Planning Application Ref: P/18/20/PL

Location: Land west of Barton House, Manor Park, Pagham

Description of works: Change of use from highway land to residential use for the development of 4no. 3 bed terraced houses with associated parking & access. This application affects the setting of a listed building

Mark Warwick
Tree Officer / Parks and Greenspace Team

Tree Retention Protection Plan

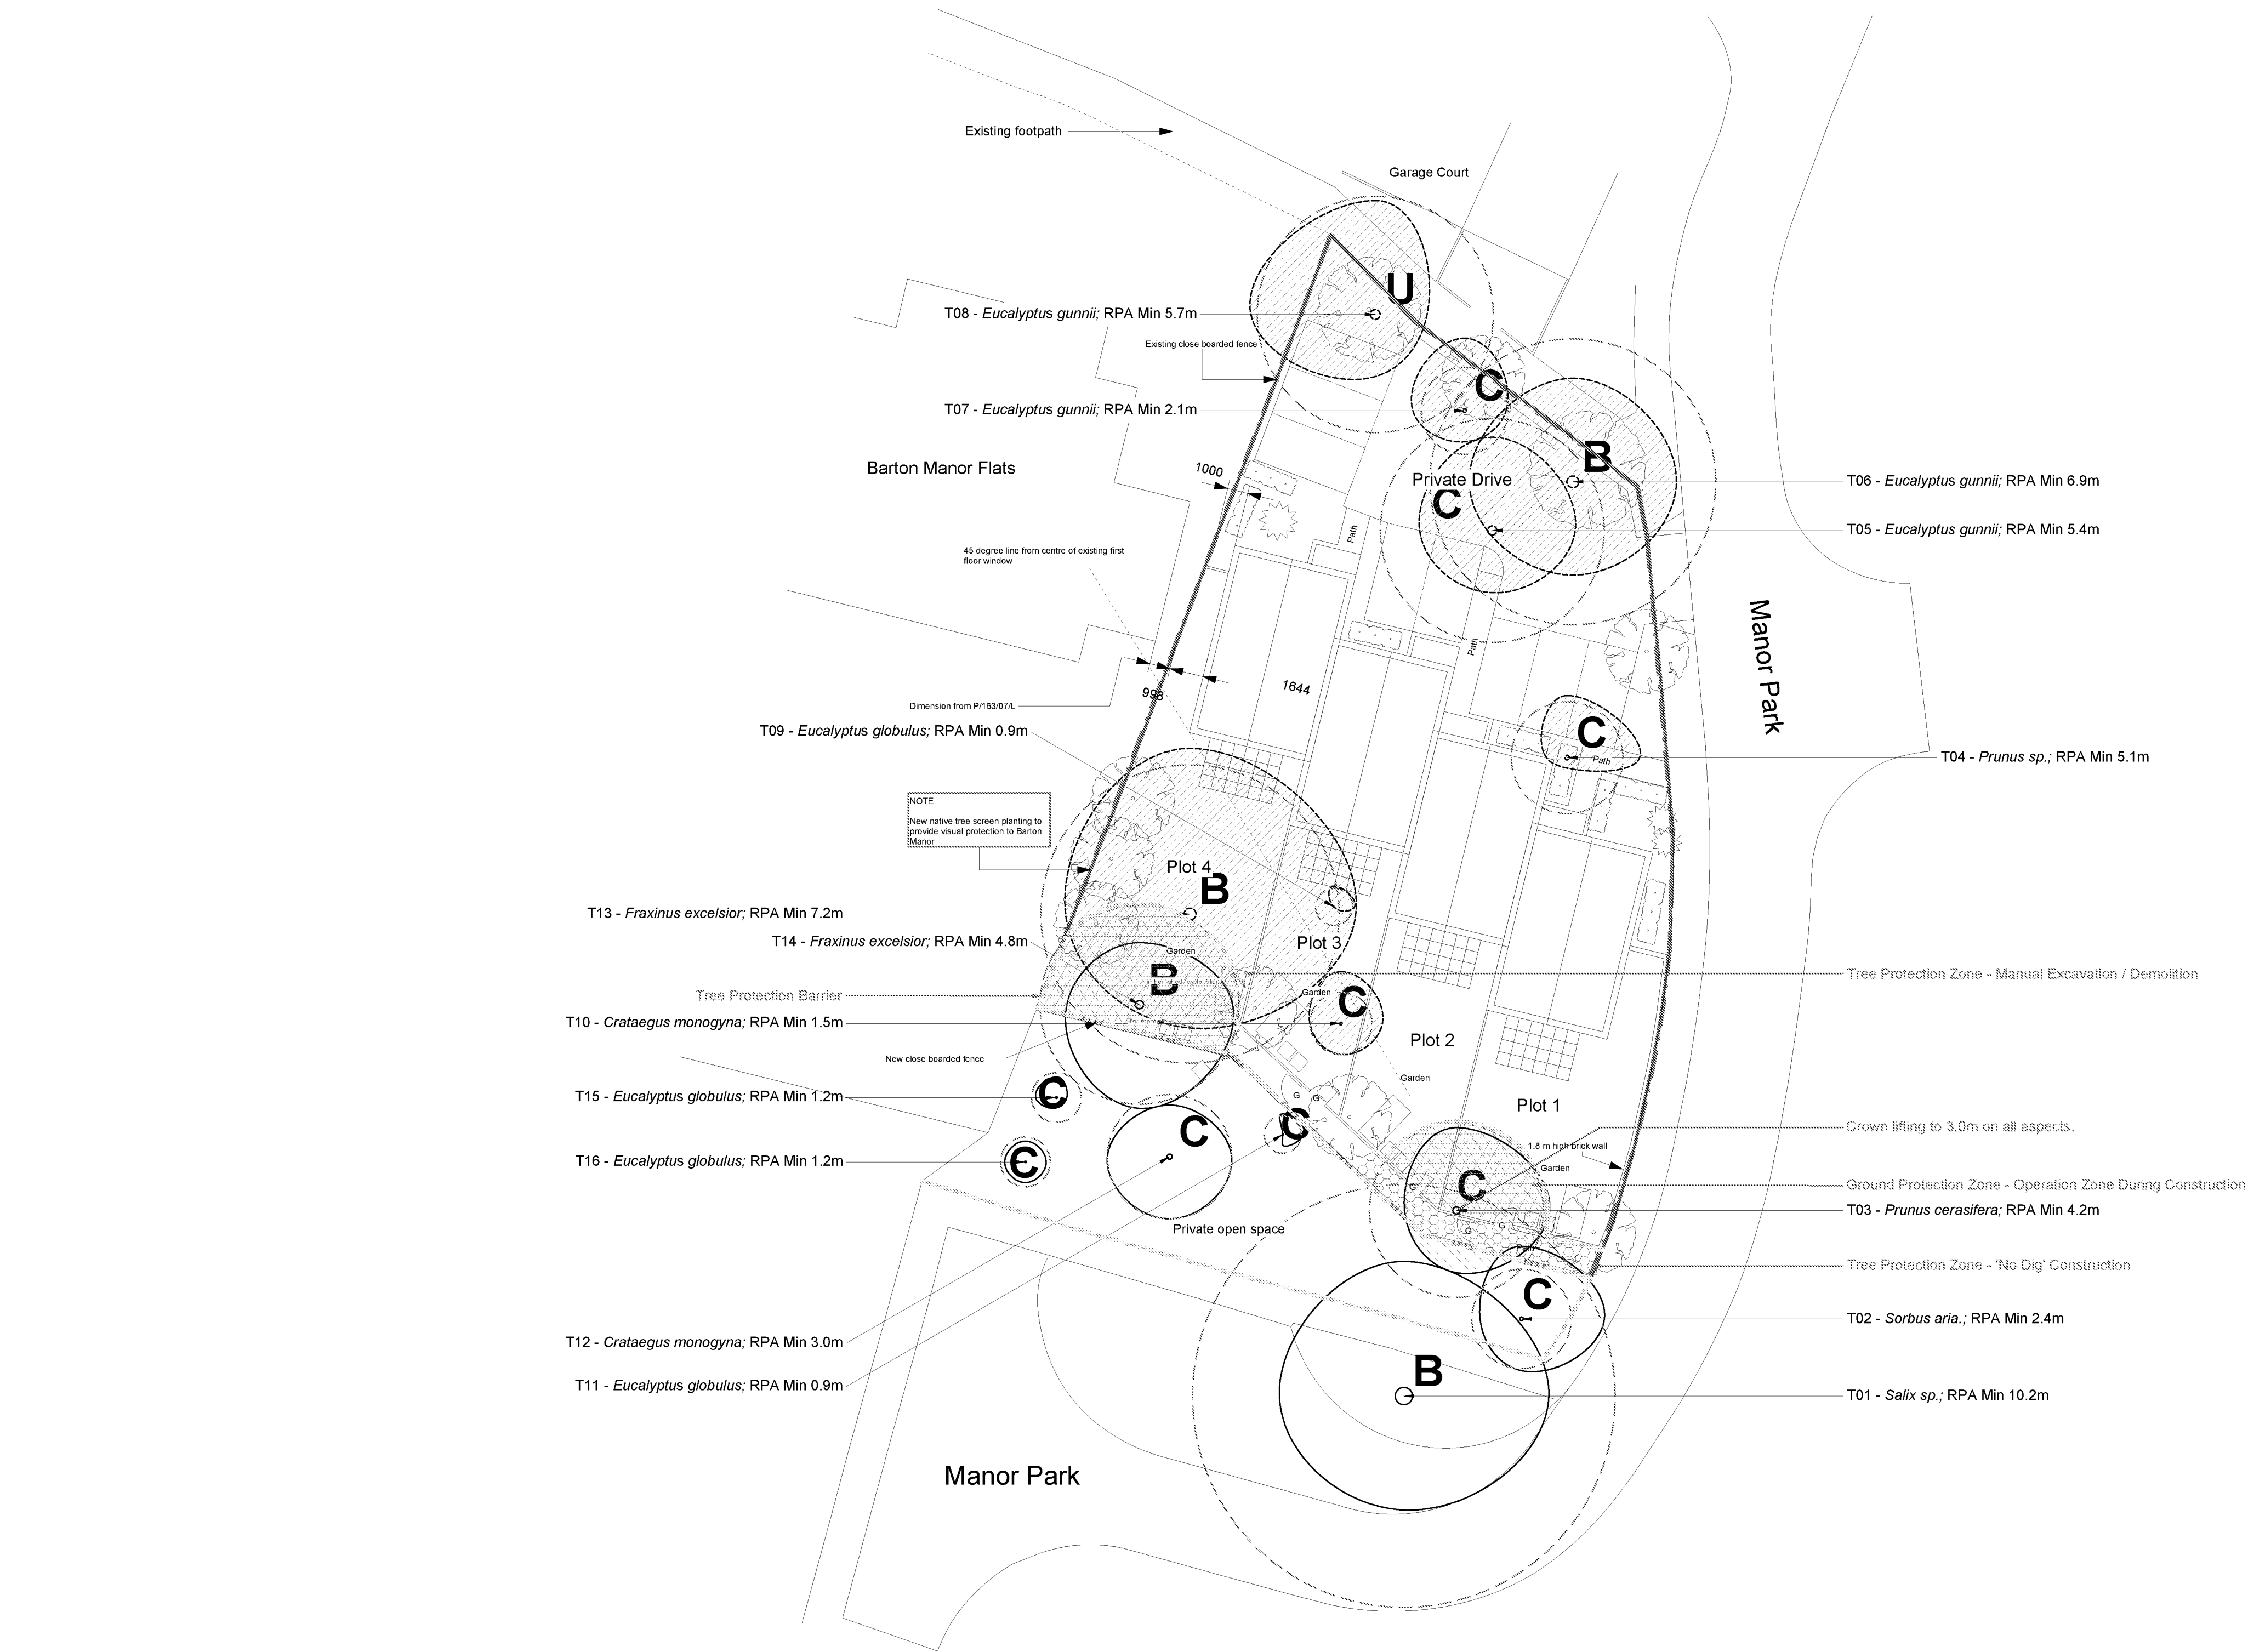
- Reference is made in the legend of TRPP (Notes: item 3.) to the aforementioned AIA/MS (LLD1899-ARB-REP-001), although I can see no record of this document having been submitted. This is a critical omission, as it should describe key elements of the proposal such as; timing and phasing of operations, methods of working within the root protection area of retained trees, frequency of supervision and record keeping.

- This a busy layout on a relatively confined plot and so we will need to see a Construction Management Plan (that fully complements the TRPP), to clearly show where the intended route of heavy plant is to occur across the site, siting of any compound area, area for delivery and storage of materials and details of any other potentially harmful practice associated with the proposal. This to ensure we can be confident retained on/off-site trees will not be negatively impacted throughout development. This will need to be included in a condition forming part of any APPROVAL.

- I recommend the above scheme for **APPROVAL**, subject to the following conditions being applied:
1. Before the site is occupied or any machinery is introduced to the site or demolition work or construction work or alterations to existing ground levels takes place a **PRE-COMMENCEMENT Site Meeting** is to take place between the Planning Authority's Tree Officer and the Arboricultural Expert representing the site owner(s) – at this meeting all protective fencing and ground protection measures will be inspected to verify they are 'Fit for Purpose' as required under British Standard 5837:2012 and have been erected and positioned exactly as shown on the **Tree Retention Protection Plan, LLD1899-ARB-DWG-002, Rev 02.**
